**TIGER PRELIMINARY PLAT (LP-08-00022)
COMPLIANCE DOCUMENT**

LP-08-00022

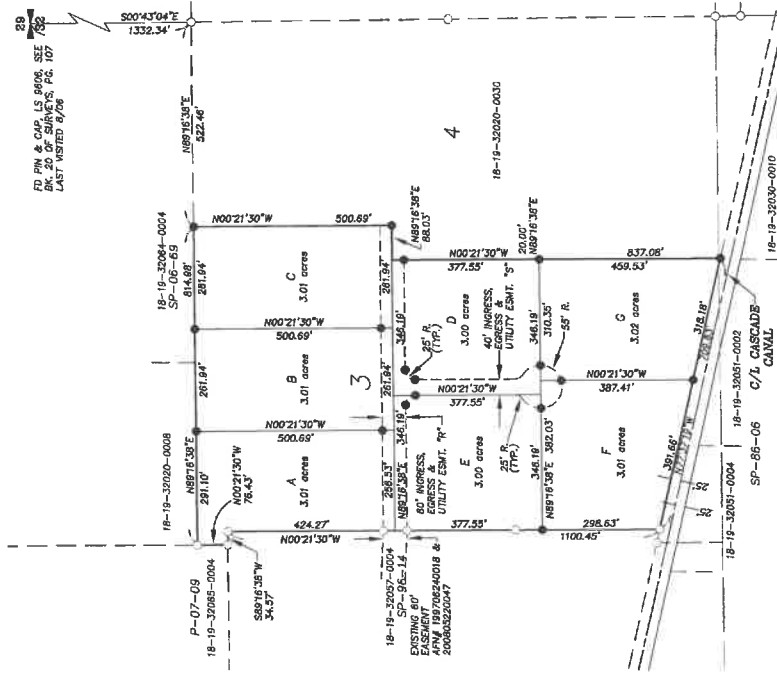
10	<p>THE FINAL PLAT SHALL MEET ALL REQUIREMENTS AS LISTED IN CHAPTER 16.20 OF THE SUBDIVISION CODE; INCLUDING CONTENT, FORMAT, ETC. THE FOLLOWING ITEMS WILL BE REQUIRED ON THE FINAL PLAT SUBMITTAL:</p> <p>A. ADJACENT PROPERTY OWNERS: THE ADJACENT PROPERTY OWNERS AND SURROUNDING PROPERTIES SHALL BE ON THE FACE OF THE FINAL SHORT PLAT.</p>	<p>Final mylars show the items requested.</p>

Item	REDUCED COMMENT	APPLICANT RESPONSE	STAFF REVIEW
	<p>(K.C.C.16.20.040, 11, PLAT DRAWING, ADJACENT OWNERS).</p> <p>B. SURROUNDING AREA: ALL SURROUNDING PROPERTY SHALL BE SHOWN IN DOTTED LINES AND LETTERS WITH NAMES OF PLATS, ROADS, ADJOINING LOTS, CANALS, AND ETC., AND IF UN-PLATTED SHALL BE SO INDICATED. (K.C.C.16.20.040, 11, PLAT DRAWING, SURROUNDING AREA).</p>		
11	<p>PRIVATE ROADS SERVING ANY OF THE LOTS WITHIN THIS DEVELOPMENT SHALL BE INSPECTED AND CERTIFIED BY A LICENSED PROFESSIONAL ENGINEER FOR CONFORMANCE WITH CURRENT KITTITAS COUNTY ROAD STANDARDS, 9/6/05 EDITION. KITTITAS COUNTY PUBLIC WORKS SHALL REQUIRE THIS ROAD CERTIFICATION TO BE COMPLETED PRIOR TO THE ISSUANCE OF A BUILDING PERMIT FOR ANY OF THE STRUCTURES WITHIN THE PROPOSED PLAT.</p>	<p>Noted. Applicant will comply prior to requesting a building permit.</p>	
12	<p>THE APPLICANT RECEIVED A VARIANCE (RV-08-29) FROM ROAD STANDARDS ON SEPTEMBER 17, 2008 ALLOWING THE FIRST PORTION OF MISSION VIEW DRIVE TO BE CONSTRUCTED AS TWO ONE WAY ROADS, AS IT CURRENTLY EXISTS. MISSION VIEW DRIVE MUST MEET ALL CONDITIONS OF A HIGH DENSITY ROAD SERVING 15-40 PARCELS, EXCEPT EACH ROADWAY MUST BE 16' IN WIDTH FOR THE FIRST PORTION OF THE ROAD.</p>	<p>Noted.</p>

26	<p>BOTH SHEETS SHALL REFLECT THE PLAT NUMBER: LP-08-22.</p>	<p>Plat number shown on both sheets.</p>	
27	<p>IF ANY ARCHEOLOGICAL OBJECTS AS DEFINED BY RCW 27.53.030 ARE DISCOVERED OR EXCAVATED, THE OWNER/DEVELOPER/CONTACTOR SHALL STOP WORK IMMEDIATELY AND NOTIFY THE KITITAS COUNTY DEPARTMENT OF COMMUNITY DEVELOPMENT SERVICES AND THE WASHINGTON STATE DEPARTMENT OF ARCHAEOLOGY AND HISTORIC PRESERVATION AS PROVIDED BY RCW 37.53.020.</p>	<p>Noted and applicant will comply.</p>
